Our reference: ECM: 8371625 & 8401244
Contact: Jane Hetherington
Telephone: 4732 8078

11 October 2018

**Site 4A, Oakdale South Industrial Estate Stage 4 – Costco Wholesale at
No. 15 Ottelia Road, Kemps Creek (SSD 8209 MOD 2) – Modification
Application**

Figure 6: Proposed Ground Floor Stage 1 Area Plan

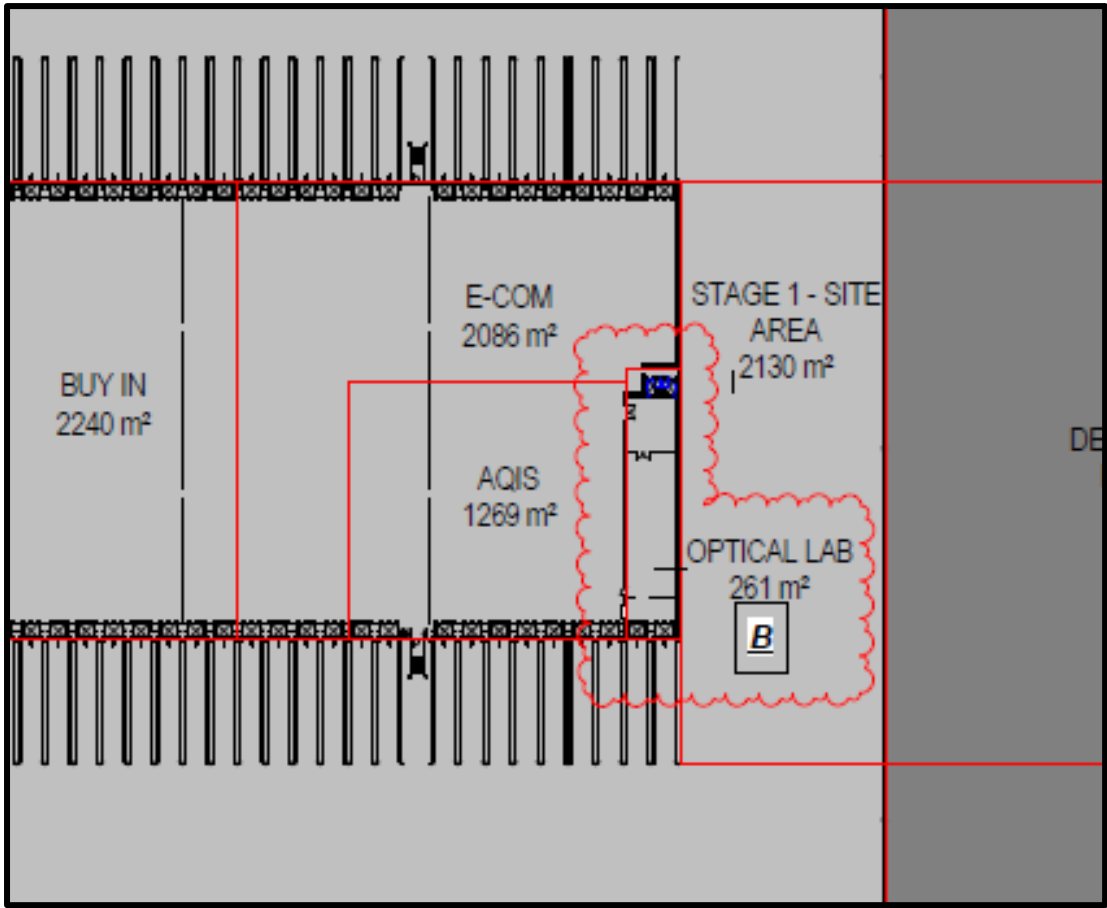
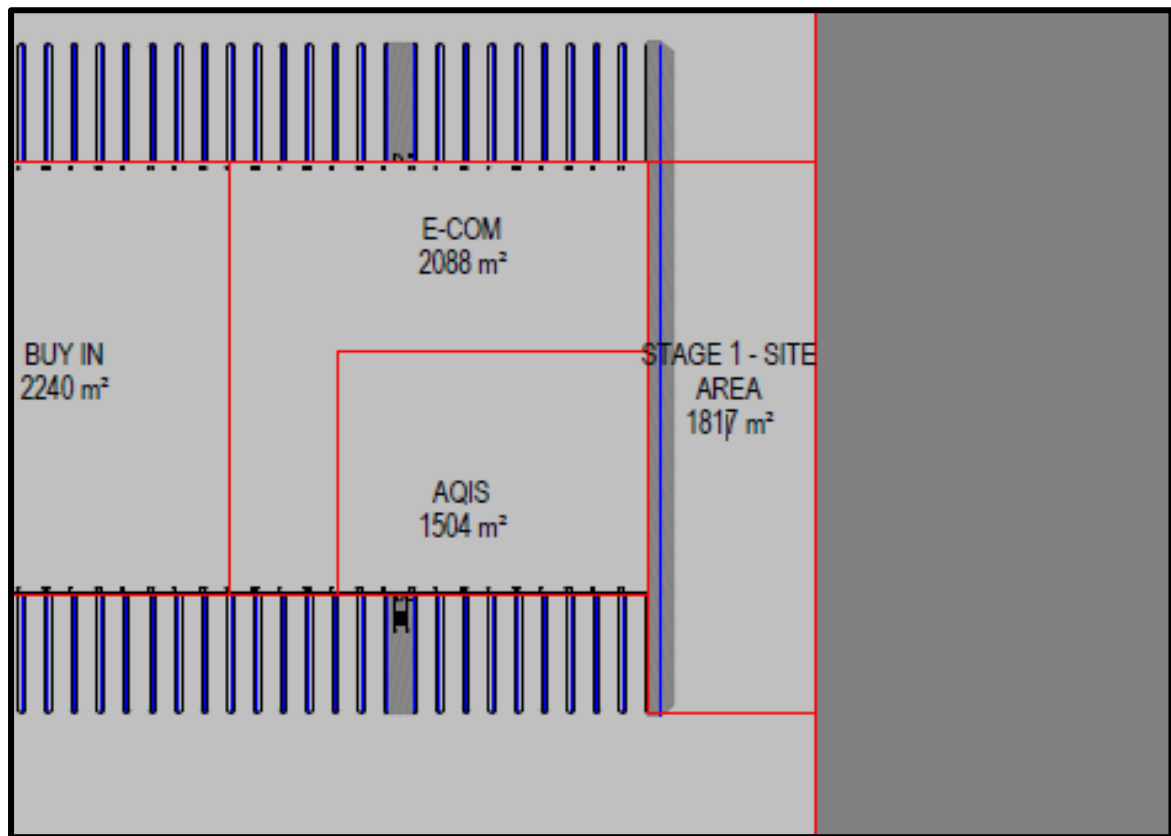
The Statement of Environmental Effects (SEE) outlines that the manufacturing process does not include the use of chemicals, and as such, has not provided any detail on any liquid polishing or treatment compounds utilised in lens finishing. Further clarification on whether these processes will be undertaken by the proposed laboratory facility is required.

a) The SEE notes that during the cutting process, water used in cutting will be filtered and recycled. "The plastic swarf is collected from the filters, dried and disposed to land fill through standard waste channels as a solid inert plastic waste." Further detail and specifications for the proposed water recycling system, including any treatment mechanisms, shall be provided for review.

b) Should it be proposed that the facility undertakes any liquid polishing or treatment compounds utilised in lens finishing, details on how any wastewater generated will be managed is to be submitted for review.

Furthermore, the above stated water recycling process does not address potentially contaminated liquid wastes generated during lens coating and polishing. Contaminated liquid waste is not permitted to enter Council's stormwater system. A Trade Waste Agreement with Sydney Water may be required for disposal of this waste.
